From: Paul Cann <Paul.Cann@arun.gov.uk>
Sent: 14 February 2023 16:45
To: Planning.Responses <Planning.Responses@arun.gov.uk>
Cc: Karl McLaughlin <Karl.McLaughlin@arun.gov.uk>
Subject: RE: Planning Re-Consultation on: Y/55/22/DOC

Application No: Y/55/22/DOC
Registered: 6th May 2022
Site Address: 10 Acre Field Grevatts Lane West Yapton
Grid Reference: 498000 101780
Category: Discharge of Condi
Description of Works: Approval of details reserved by condition imposed under Y/103/18/PL relating to conditions 8-surface water drainage, 9-discharge flows to watercourses and 10-maintenance and management of surface water drainage.

PURECON_DOC (055) 2620

100 year Return Period Summary of Critical Results by Maximum Level (Rank 1) for Storm

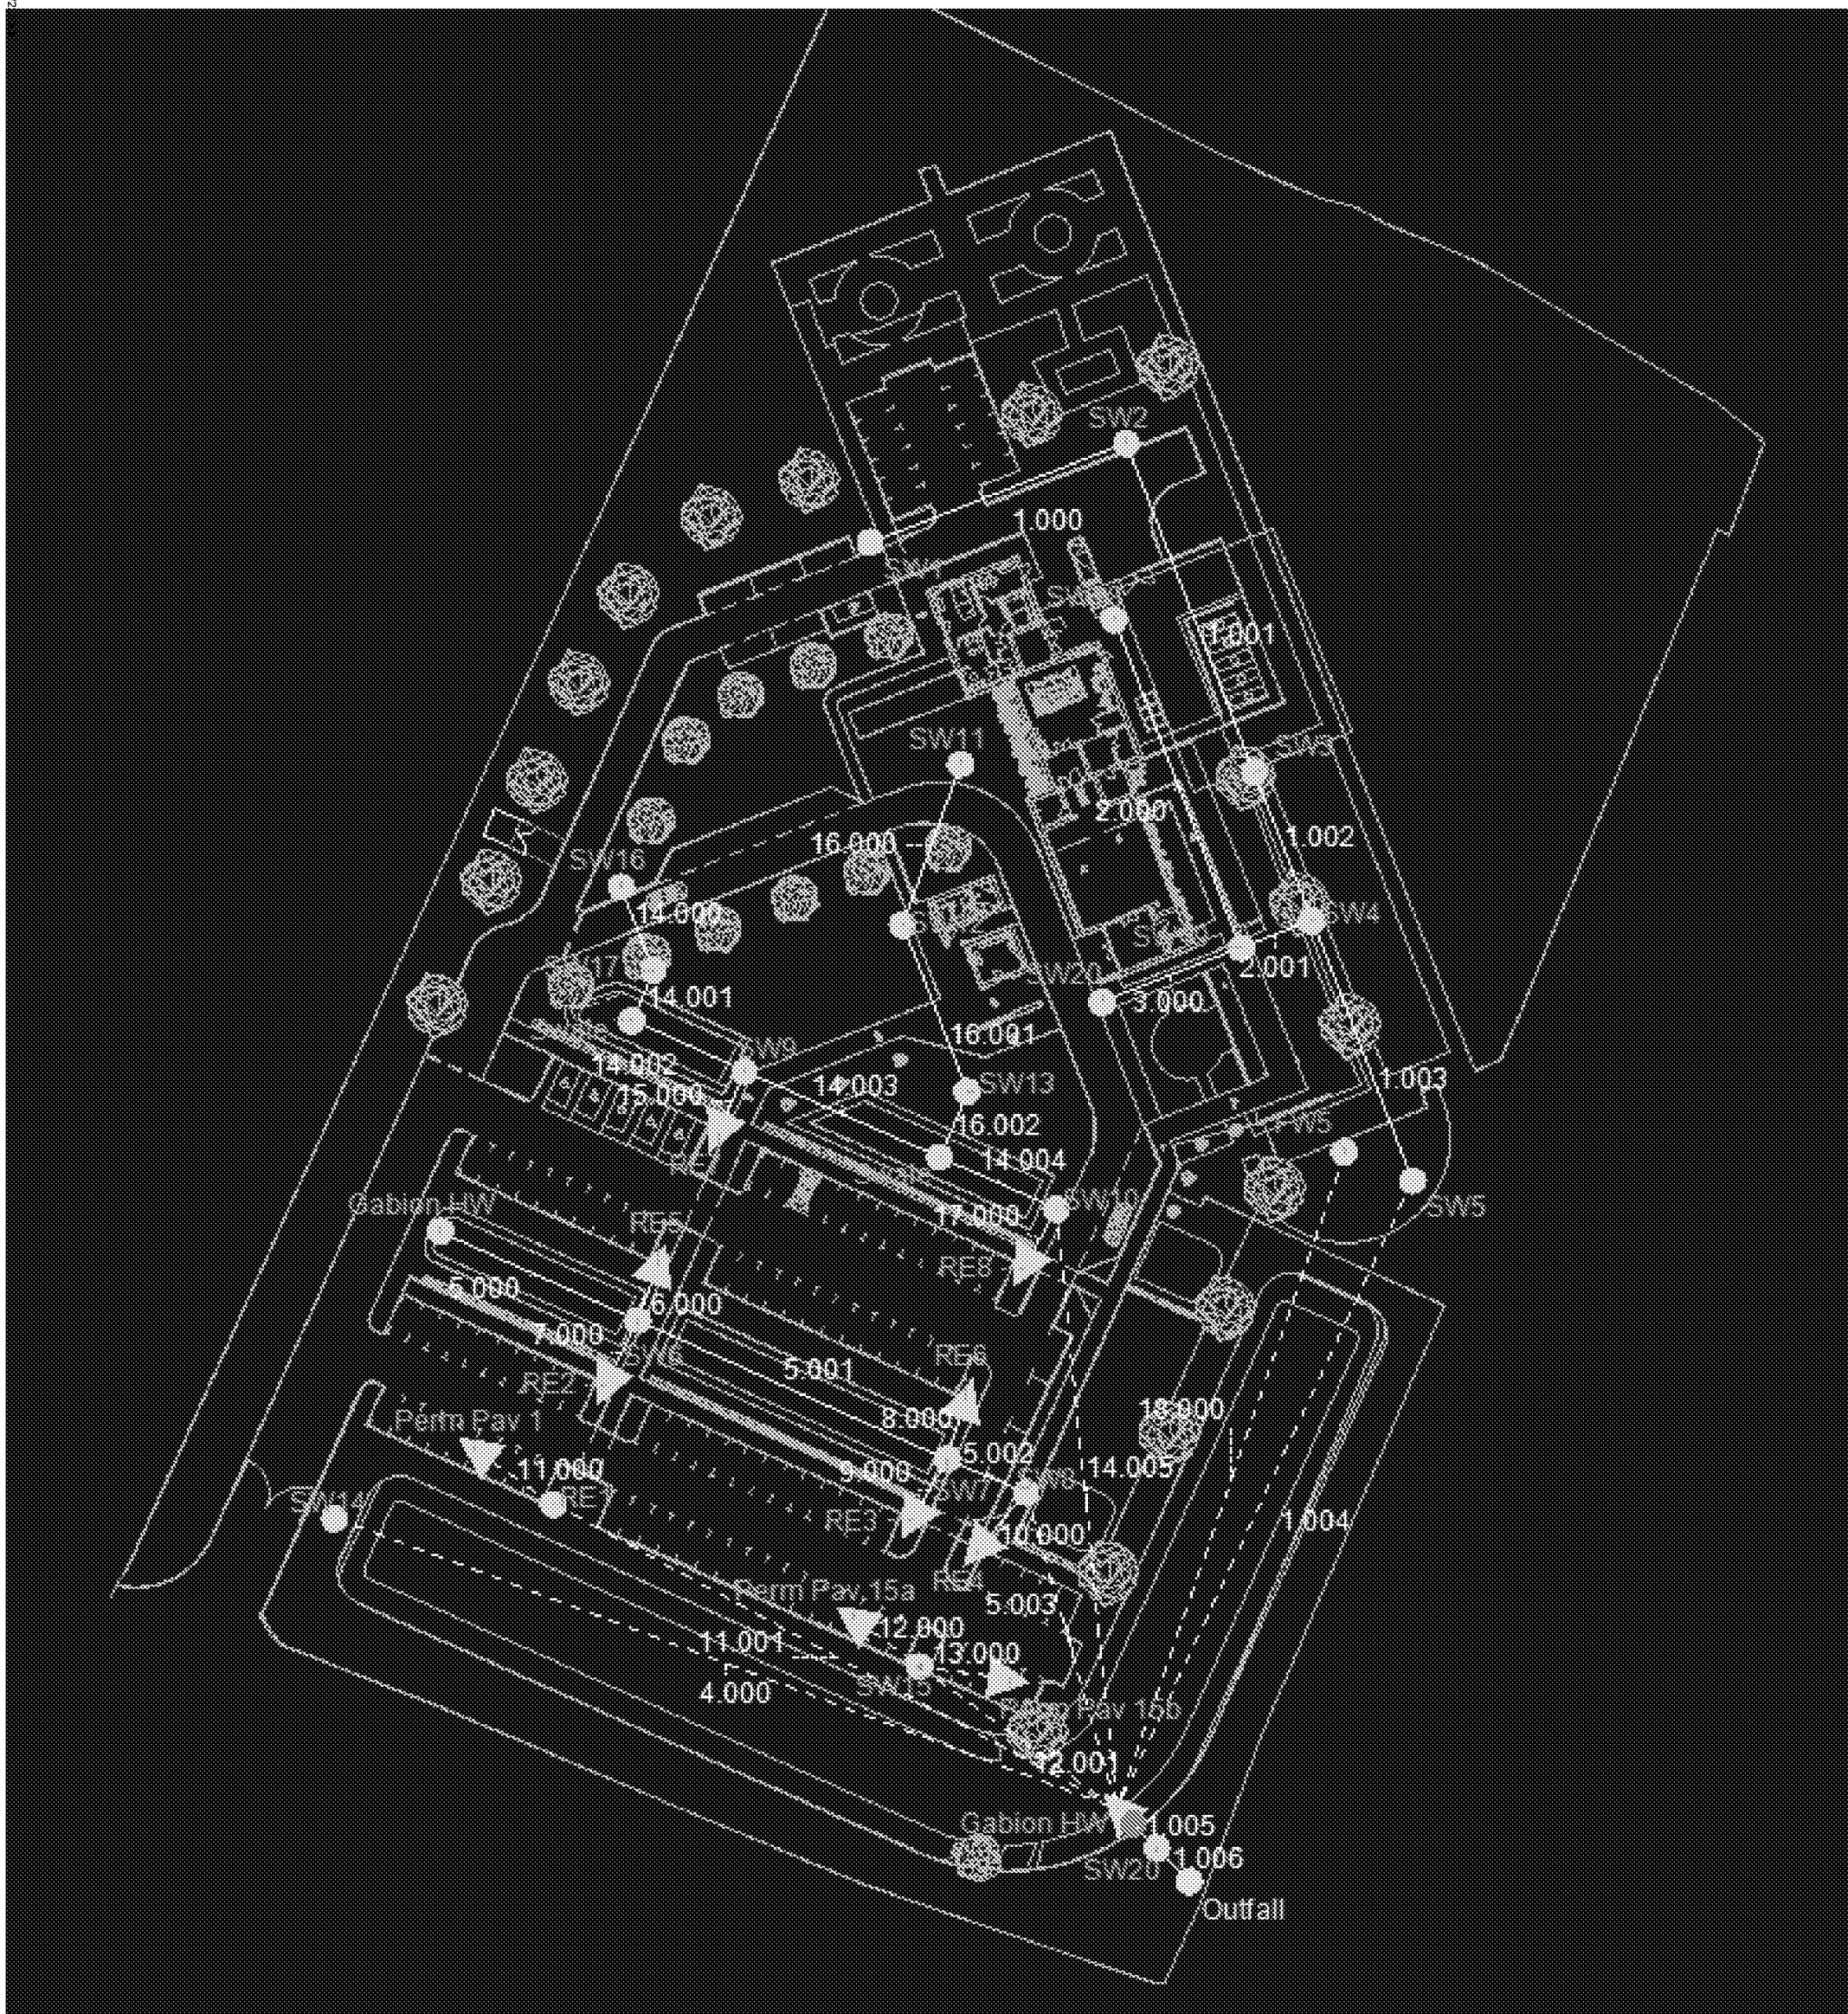
The calculations should have a surcharged outfall applied. Please update.
 - v. The calculations show Node SW2 to flood under the 1:100+cc design event, by 23.409m³. A plan should be provided to show how this floodwater can be contained safely onsite, without increasing the risk of flooding (both on and offsite). This plan should be based on the final site levels plan.

P8

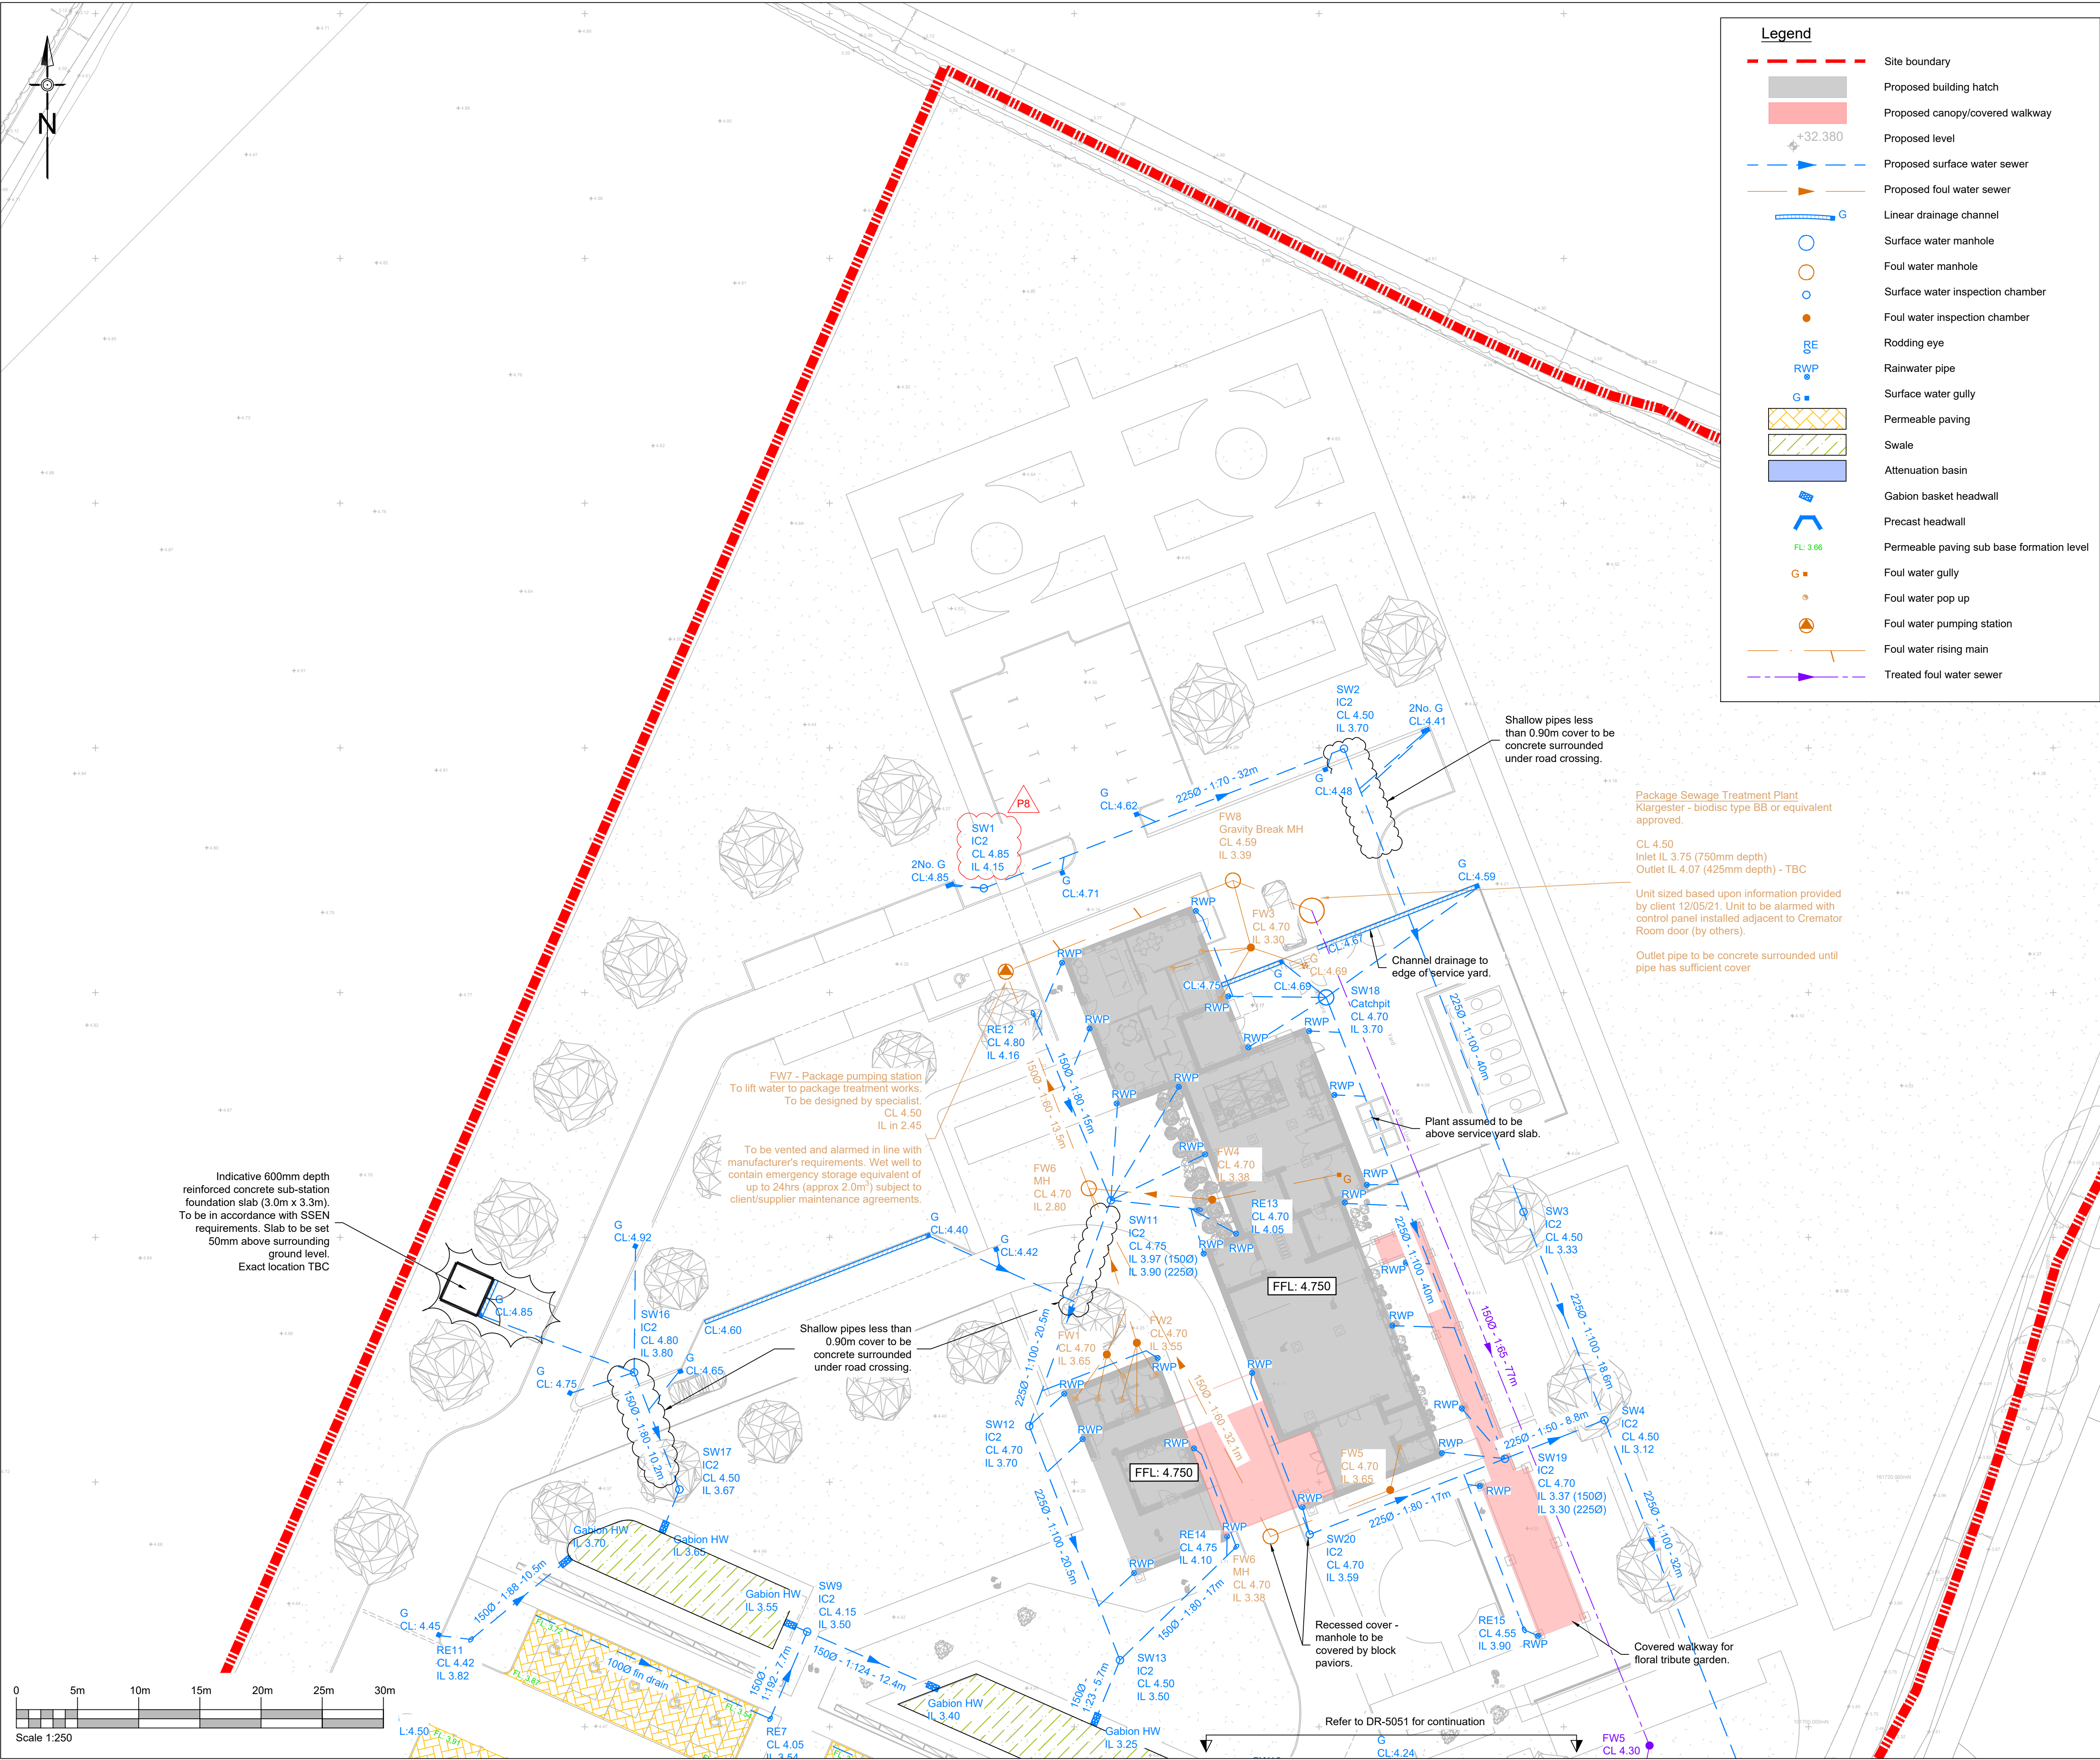
- Whilst reference has been made to the Factual Ground Investigation Report GL24235 by Harrisons dated May 2021, (ref. note 15, drawing CRH-XX-XX-DR-C-5050-P8_Proposed Drainage Layout (Sheet 1)), this information does not appear to have been submitted for review. The value specified in the applicant's response (infiltration rate of 2.37×10^{-6} m/s), has been applied to the model (calculation pack 0008 - utilising infiltration in the bases of the attenuation basin and the areas of permeable paving as requested). The results of groundwater testing have not been provided.

infiltration testing information has now been provided. However, the rate used within the calculation is an average and not the lowest rate recorded. Please apply the lowest recorded rate to the calculations.
